Re: KAG Ford Service Center – PA23-024 – Technical Review 1
16100 Smokey Point Blvd – APN(s): 31052900400600

After review of the preliminary Site Plan Review, the Planning Division has the following comments:

Re: **Project Name:** Kendall Auto Group-Ford Service Center

Proposal: New construction of a 52,000 SF service center for medium-duty and super-duty trucks with 24 service bays. The facility is not intended for automobiles and standard pickup trucks.

D2 TRASH/RECYCLING ENCLOSURE AND BATTERY STORAGE
A101 1/4" = 1'-0"

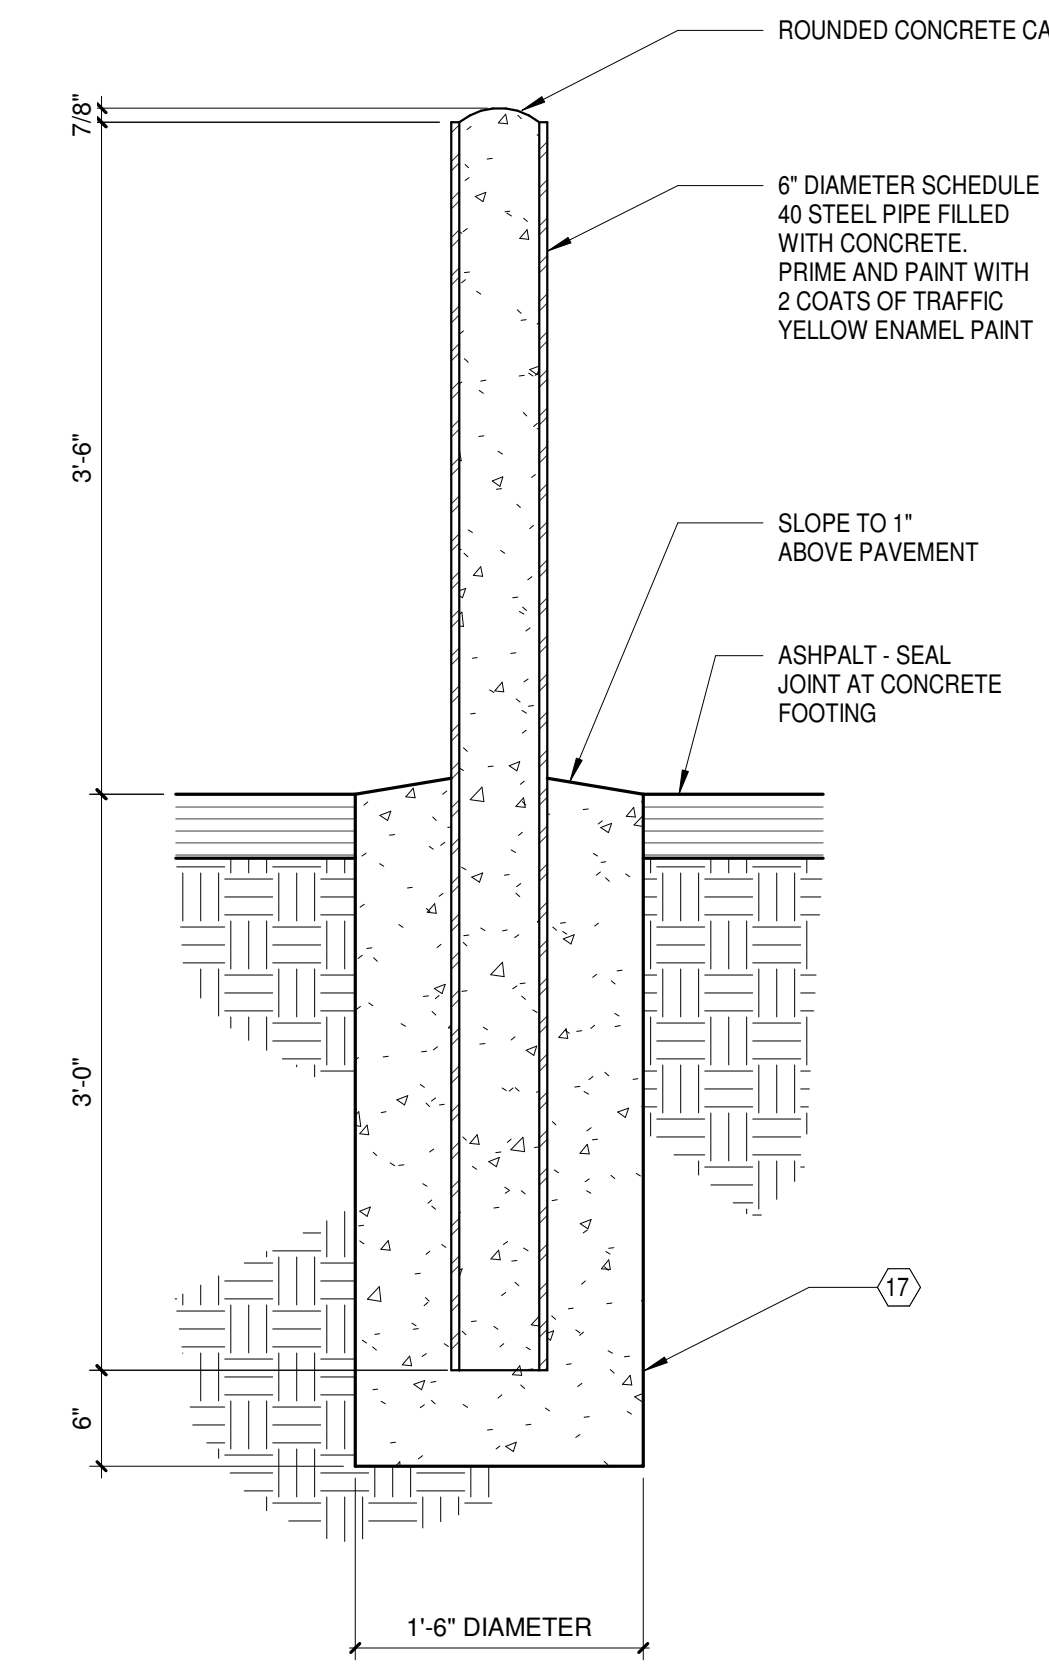
3. Provide on plan set the amount of batteries, if any, will be stored in the proposed structure.
4. Contact our office if you have questions in regards to permit applications, checklists and/or handouts that you and/or your design team will be preparing plans for on your project.

DATE: OCT 17, 2023
PROJECT NO: 2310.00
SHEET:
A101
SITE PLAN

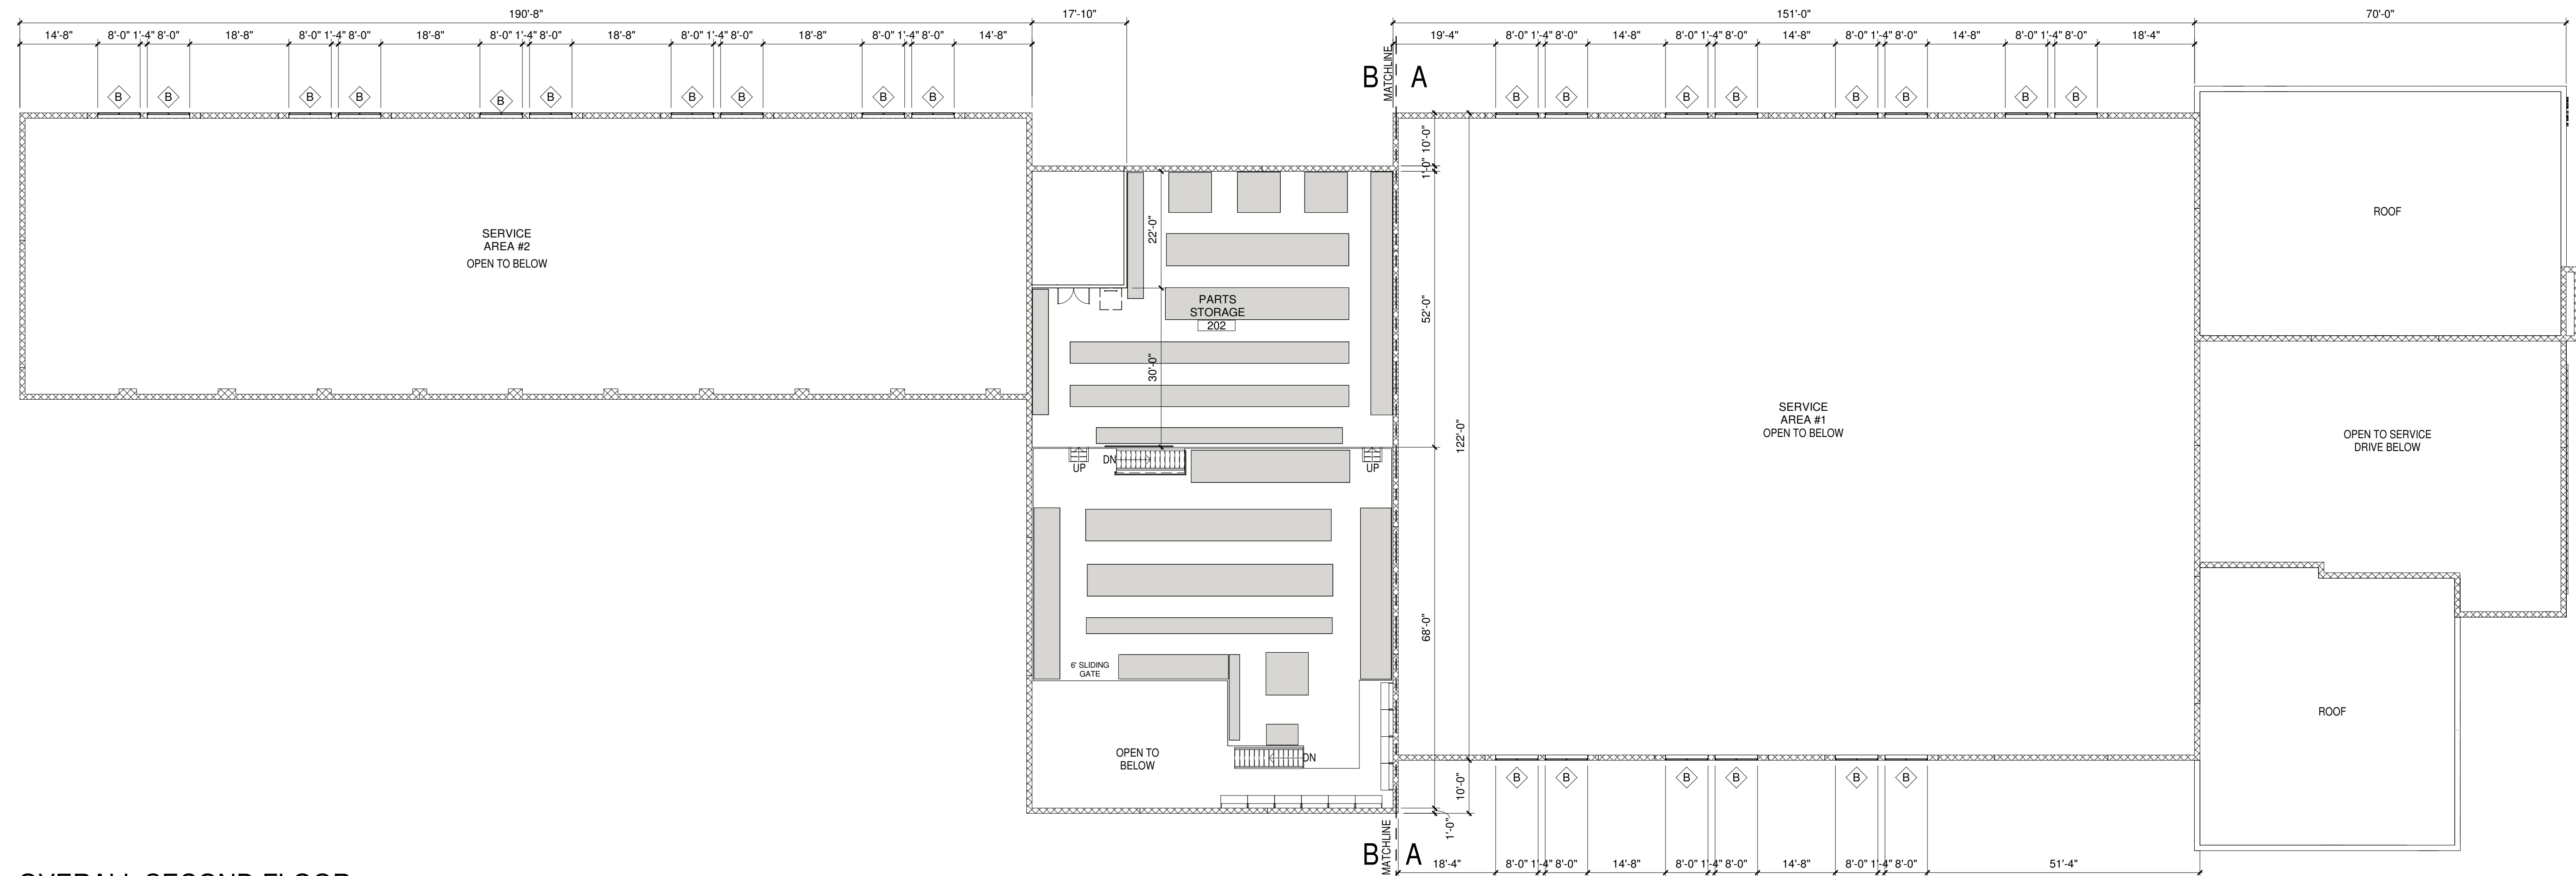
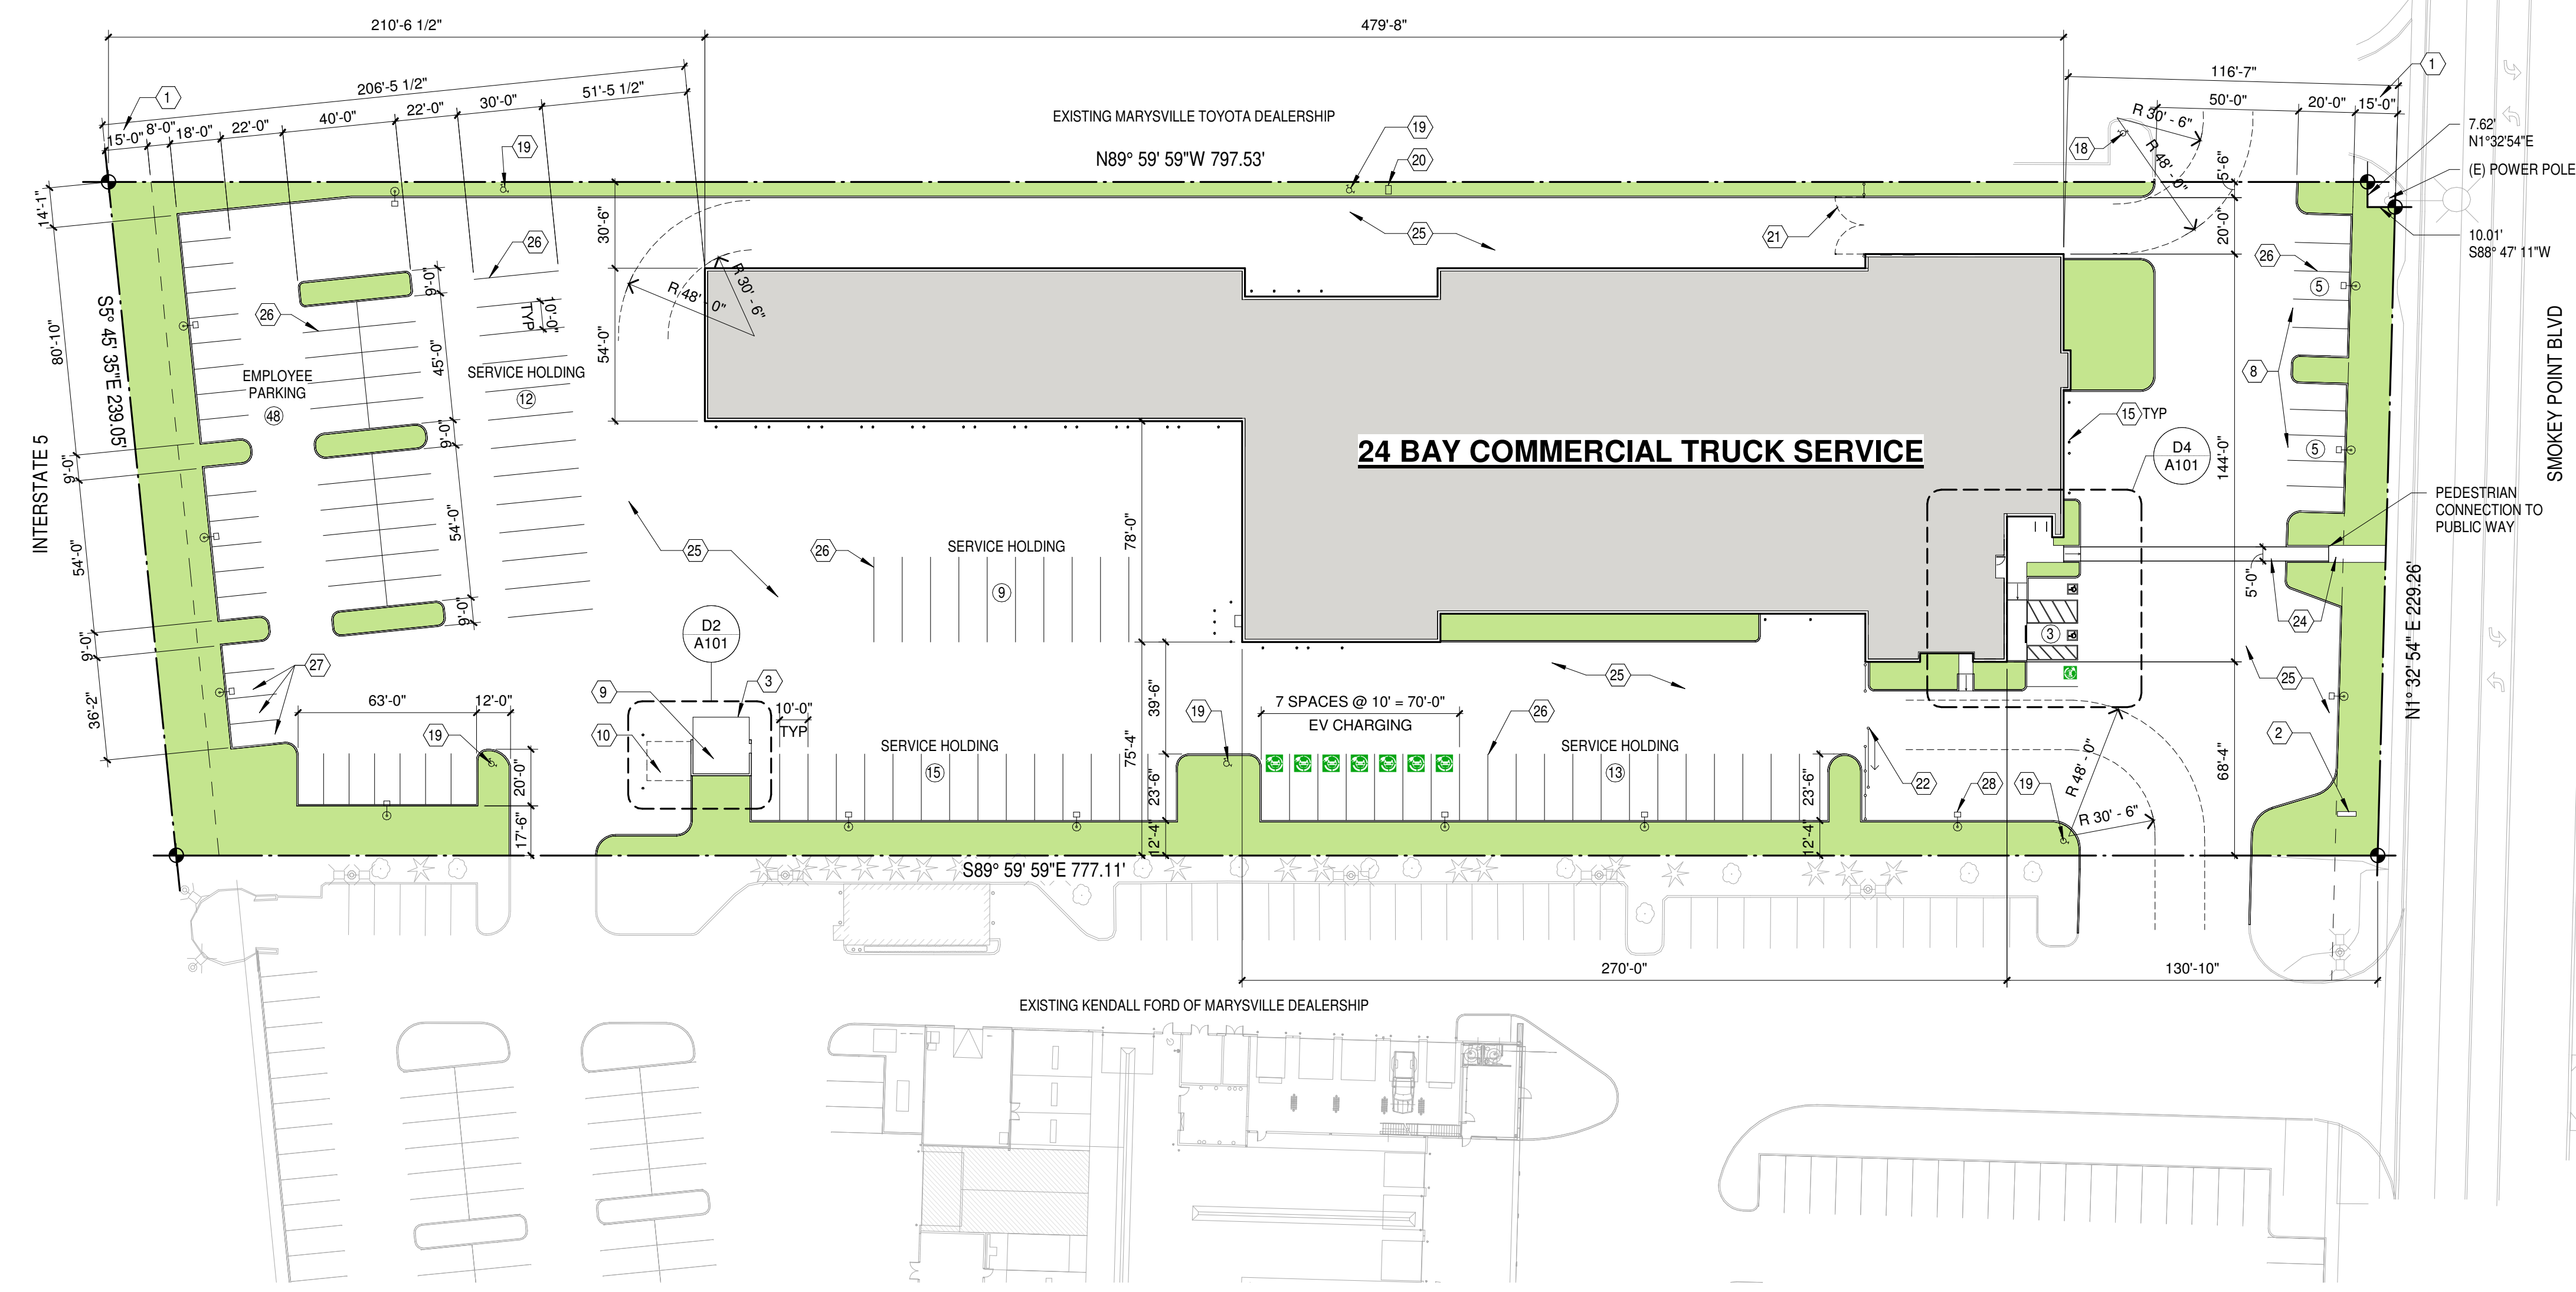
4. The proposed signage must be reviewed and approved under a separate sign permit. Signage must be designed for compliance with MMC 22C.160.
5. Please add calculations for how the total number of required parking spaces was determined. Per MMC 22C.130.030, off-street parking spaces must be calculated for the proposed uses as listed below:

- 5.1. Motor Vehicle Repair – 2 spaces plus 2 spaces per service bay
 - 5.2. Office – 1 space per 400 sq. ft. of gross floor area.
6. Bicycle parking shall be provided at a rate of 5% of the number of required off-street auto parking spaces. Design and location shall be provided in accordance with MMC 22C.130.060.

4. Site plan is to show the distance from the proposed structure to the property lines, from all sides of the building.
5. A Fire Sprinkler system will be required. The applicant is to verify these requirements with the Fire Marshal's Office.

A1 OVERALL FIRST FLOOR
A111 1/16" = 1'-0"

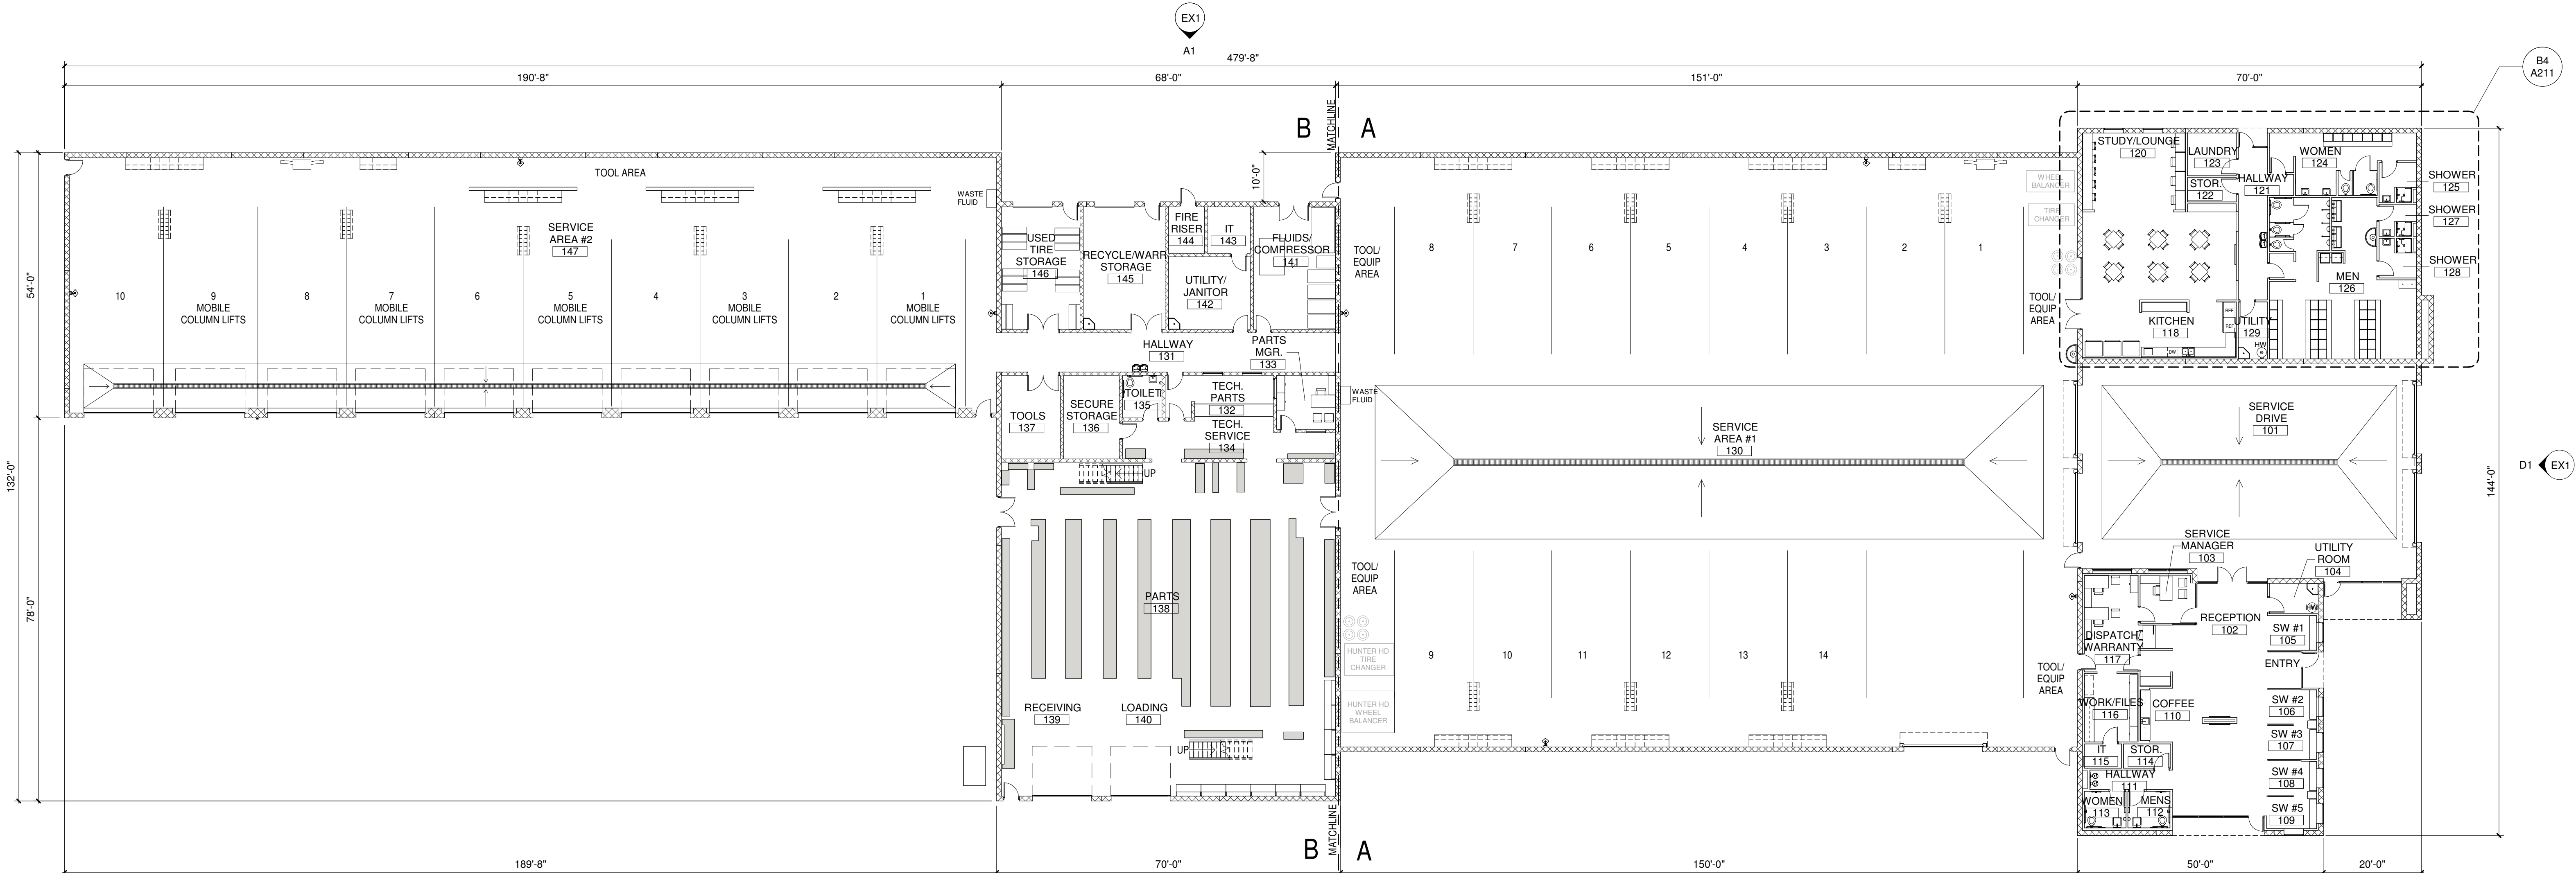
2. Please provide scaled floor plans with square footage.
3. Show on the plans the type of building materials proposed, and if required, what type of fire-resistant construction will be required.
